## **FIRE RISK MANAGEMENT, INC**

# **Memo Report**

**Subject: Fire and Life Safety Evaluation of 1844 Forest Ave., Portland, ME**

Existing structure

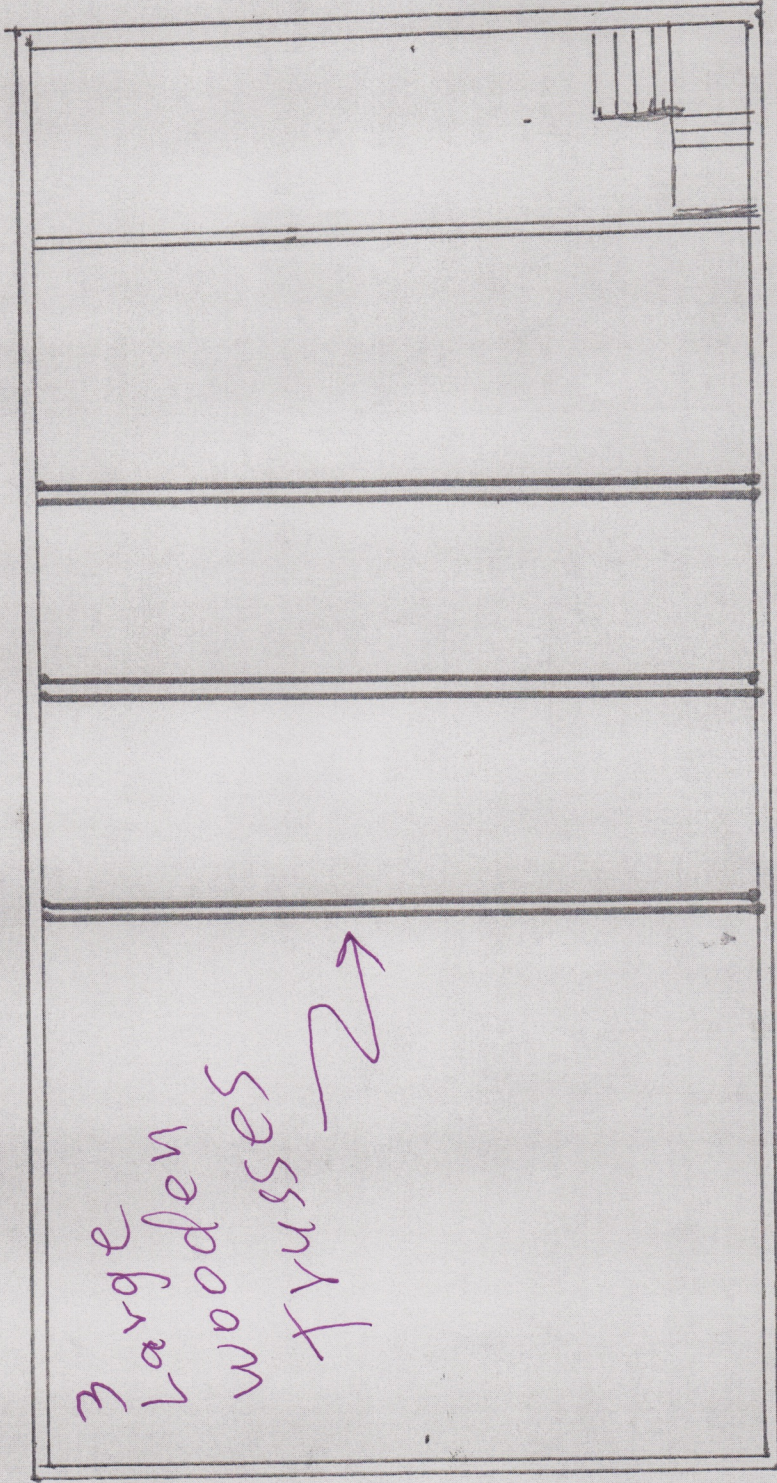
Based on a site review of the building performed on 10 September, 2014, the primary structural components appear to consist of heavy timber (HT) construction. This includes the floor/ceiling assembly between the basement and 1<sup>st</sup> floor levels. Although the framing of the floor/ceiling assembly between the 1<sup>st</sup> floor and attic space is also heavy timber, the ceiling of the 1<sup>st</sup> floor consists of architectural “tin” ceiling material that is attached directly to the ceiling/floor joists.

Fire separation
Floor design detail

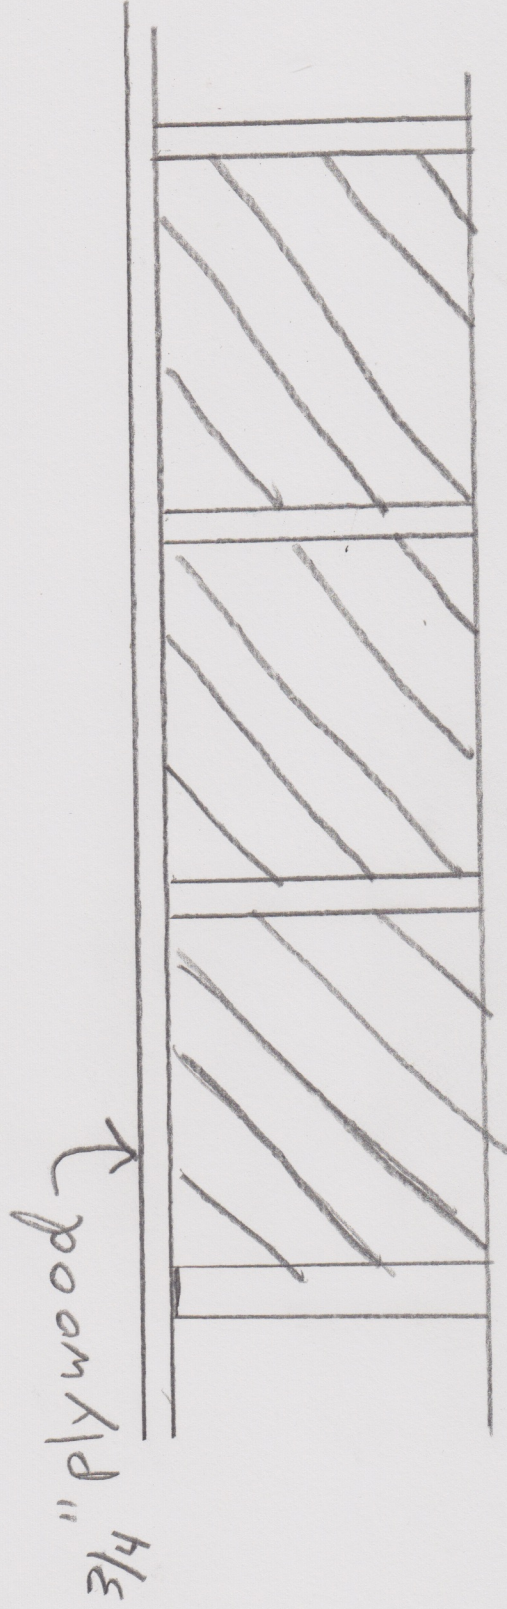
Based on the code requirements outlined in the IBC, it would be necessary to provide a 1-hour fire separation between the assembly and residential portions of the building. Although heavy timber construction is generally considered as having an inherent 1-hour fire resistance, the existing floor/ceiling assembly separating the 1<sup>st</sup> and 2<sup>nd</sup> levels would not likely meet that definition due to the lack of a “timber” flooring material, that typically consists of wood planking; usually  $\frac{3}{4}$  to 1 inch in thickness.

1. The residential unit should be separated from the assembly area below using a floor/ceiling assembly that provides up to a 1-hour of fire resistance. Although heavy timber construction will inherently meet that requirement, there is no existing timber flooring at the 2<sup>nd</sup> floor level. To achieve the necessary 1-hour fire resistance, it is recommended that the space between the floor joists be completely filled with a non-combustible insulation material, filling all void spaces within the floor assembly. Equally, a wood subfloor should be installed that has a minimum  $\frac{3}{4}$  inch thickness.
